Regulatory, Planning and Assessment.MBisson/GMansfield
Reference: SD2020/0006
Phone: 02 4974 2000

5 July 2021

**38 LOOKOUT ROAD, NEW LAMBTON HEIGHTS - JOHN HUNTER HEALTH
AND INNOVATION PRECINCT (SSD-9351535)**

Figure 8 – Bulk Earthworks Plan – refer to appendices for details

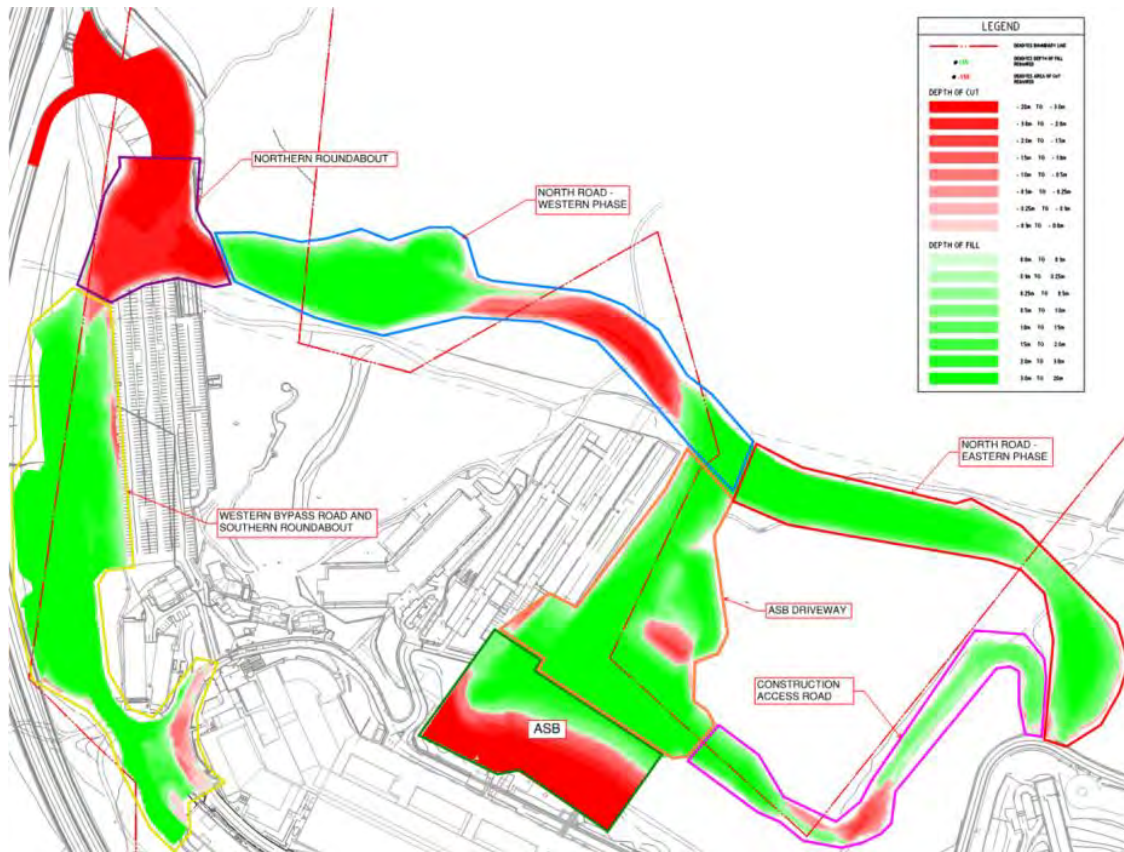
- The impacts of the proposed cut and fill batters and culverts to install new internal road networks. These disconnect upper bushland headwater catchments from downstream streams.

Figure 11 – Onsite detention basin locations

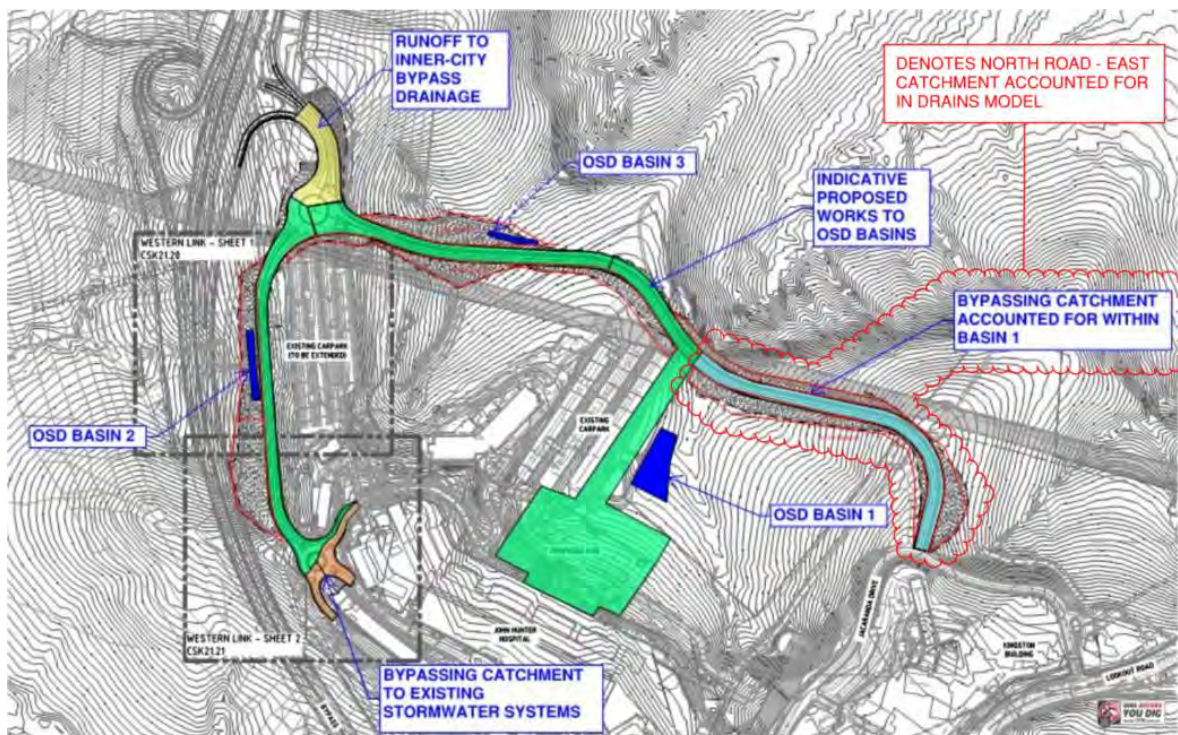
To mitigate this risk, it is recommended hydrologic objectives are achieved for the hospital development so that the Stream Erosion Index (SEI) is to be no greater than 2, where the SEI is expressed as the ratio of '*post development flow exceeding the stream forming flow*' to '*pre-development flow exceeding the stream forming flow*'. The drainage calculation method for checking and achieving this SEI objective are outlined in the Stormwater and Water Efficiency Technical Manual – Section 4.15 of the NLEP 2012. This target is derived from best practice hydrology – the CRC for Catchment and Creek Hydrology. It may be achieved through careful detailed design of inlets and outlets of proposed biobasins.

Figure 14 - Stormwater Culvert locations and Catchments

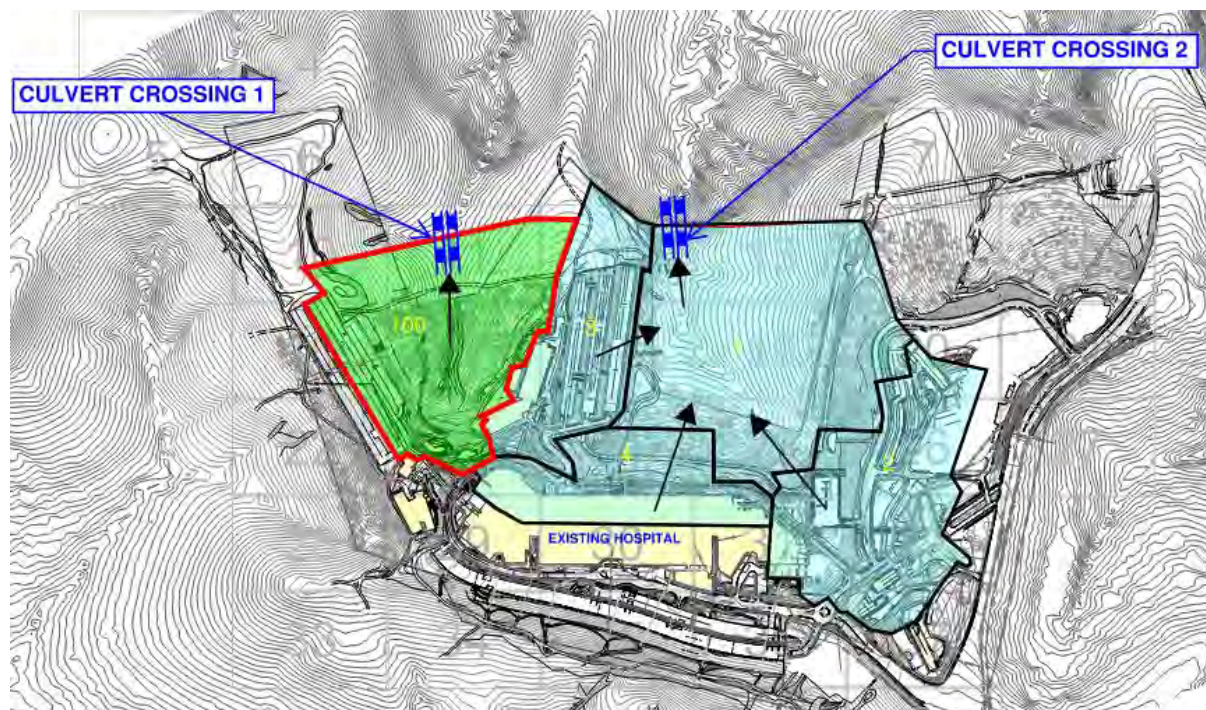
It is further recommended that the designs are amended to ensure culverts and pipes which discharge into downstream bushland include rock stabilised energy dissipator outlets, which apply natural channel design principles. The site specific, expert design and construction of these will protect upstream infrastructure from bed erosion risks. Unchecked, bed erosion can migrate upstream. Given the downstream contours (C100-DA-5) CN suggests rockwork is needed for respectively 20 and 40/50 metres to locations where the receiving waterway's longitudinal grade reduces.
